PLANNING PERMISSION FOR DEVELOPMENT SUBJECT TO REGULATION 3

Application Number: 2025/48/93197/W

ERECTION OF FREE STANDING SINGLE STOREY STRUCTURE TO BE USED AS A TEMPORARY INDOOR MARKET (SUI GENERIS) WITH ASSOCIATED FACILITIES, OFFICE CABINS, WASTE COMPOUND, PARKING SPACES AND WORKS (WITHIN A CONSERVATION AREA)

At: ADJ, HUDDERSFIELD OPEN MARKET, BROOK STREET, HUDDERSFIELD, HD1 1RY

SCALE	DRAWN	CHECKED	DATE
1:100 @ A1	FP	NM	17/11/2025
DRAWING NUMBER	REVISION		
HMH-GSA-TM-XX-D-A-3200	P02

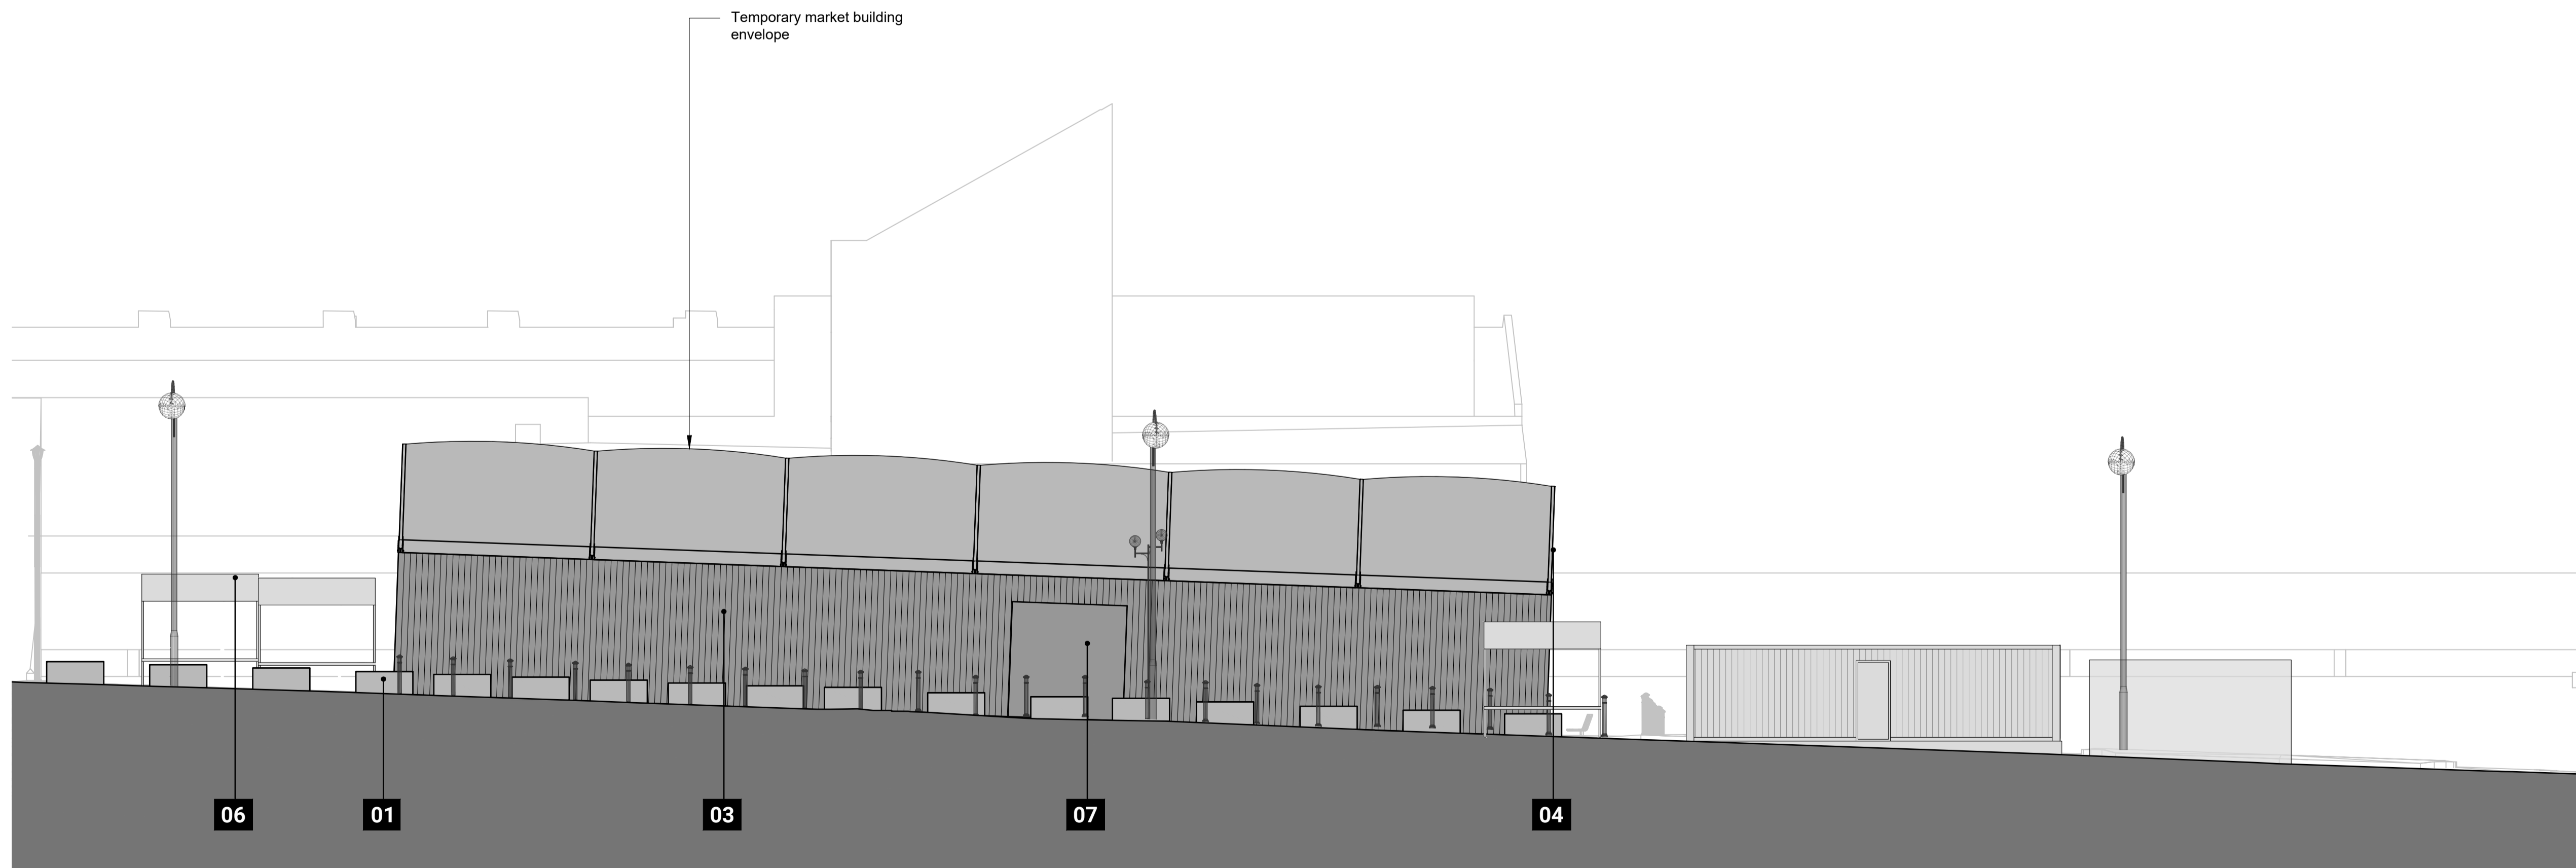
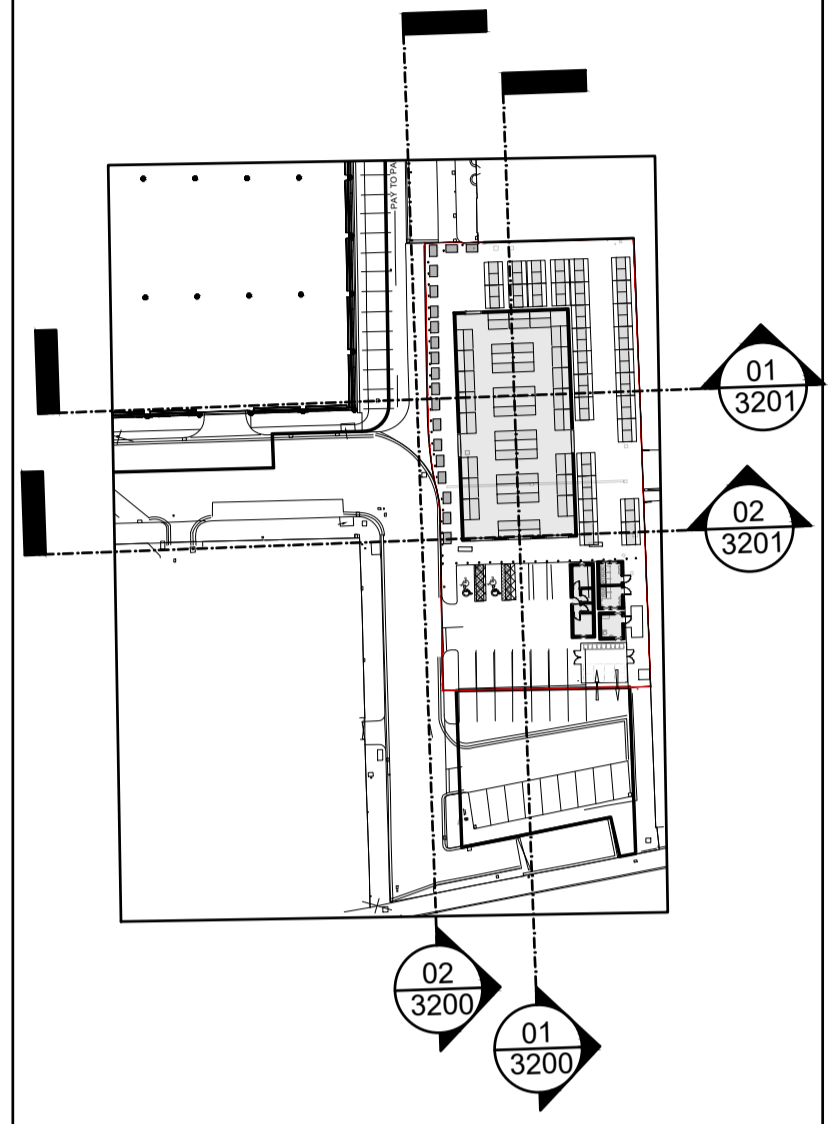
8. The colour finishes of the buildings annotated 'Male + Female Temporary toilet cabin', 'Market operations office cabins', 'Accessible toilet cabin' as well as the walls and roller shutters of the building annotated 'Temporary Covered Market Canopy' upon submitted drawing ref: 1003RefP02 shall be of a dark grey or black colour finish.
